**RE: BEGA VALLEY HEALTH REDEVELOPMENT HLS DESIGN
DOCUMENTATION REVIEW**

Following our original letter of advice dated 5 March 2012 (Ref: S12001AL001Rev1), as requested REHBEIN Airport Consulting has conducted a review of master plan concept designs provided by email on 12 July 2012 for the proposed new Bega Valley Hospital and HLS with regards to compliance with the relevant aviation guidelines and standards.

- Drawing SK_101 – Master Plan, dated 25 June 2012;
- Drawing SK_101 – Master Plan with Future Expansion, dated 8 June 2012;
- Drawing SK_102 – Aerial Views; and
- Drawing SK_103 – Section, dated 22 June 2012.

## 2. HELIPAD SITING

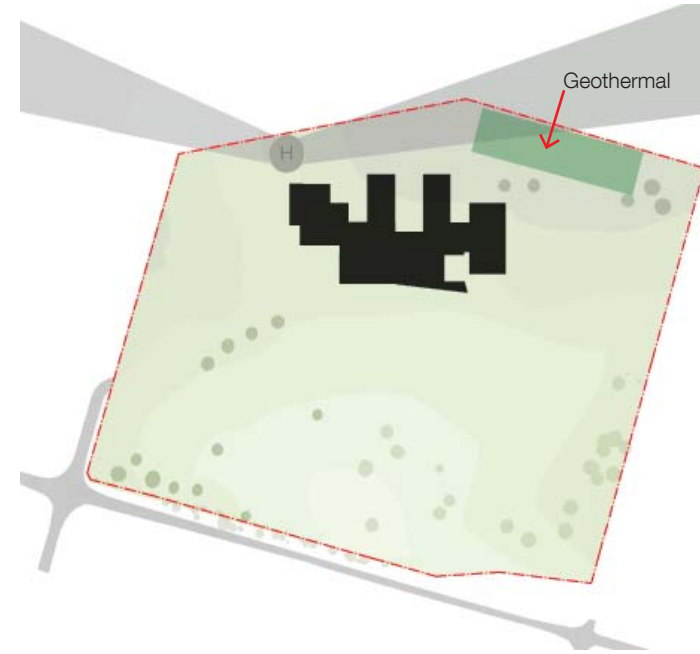
The diameter of the FATO proposed by BVN is 25m with a safety area of 4m around the FATO for a total diameter of 33m. These dimensions are in accordance with the draft NSW guidelines.

The proposed preferred flight paths are oriented 132° and 342° and are separated by a 150° obstacle free sector that can be used for arrivals and departures in high winds.

Wind analysis suggests that the preferred flight paths would provide approximately 75% usability and the entire 150° obstacle free sector should provide close to 100% usability.

The proposed flight paths are in accordance with the draft NSW guidelines.

The eastern wings of the proposed main hospital building are within the Obstacle Identification Surface (OIS) and may need to be lit for night helicopter operations. The requirements for obstacle lighting on the hospital building will need to be confirmed through consultation with the helicopter operators.

## 3. IDENTIFYING A ZONE FOR GEOTHERMAL BORES

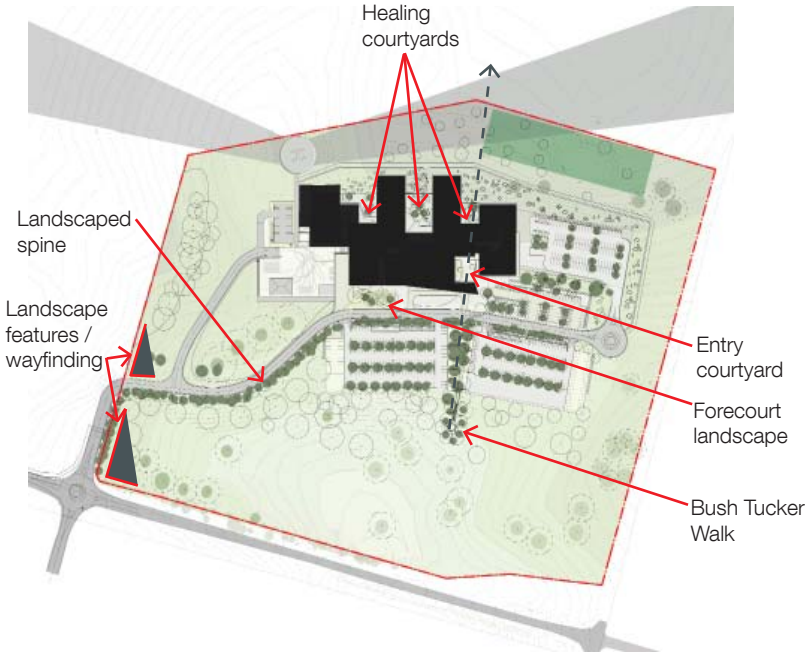
It should be noted that geothermal bores are indicated to the south east of the proposed HLS. Depending on their height above ground, objects in the area could potentially infringe the OLS. Proposals for this area should consider flight path protections requirements.
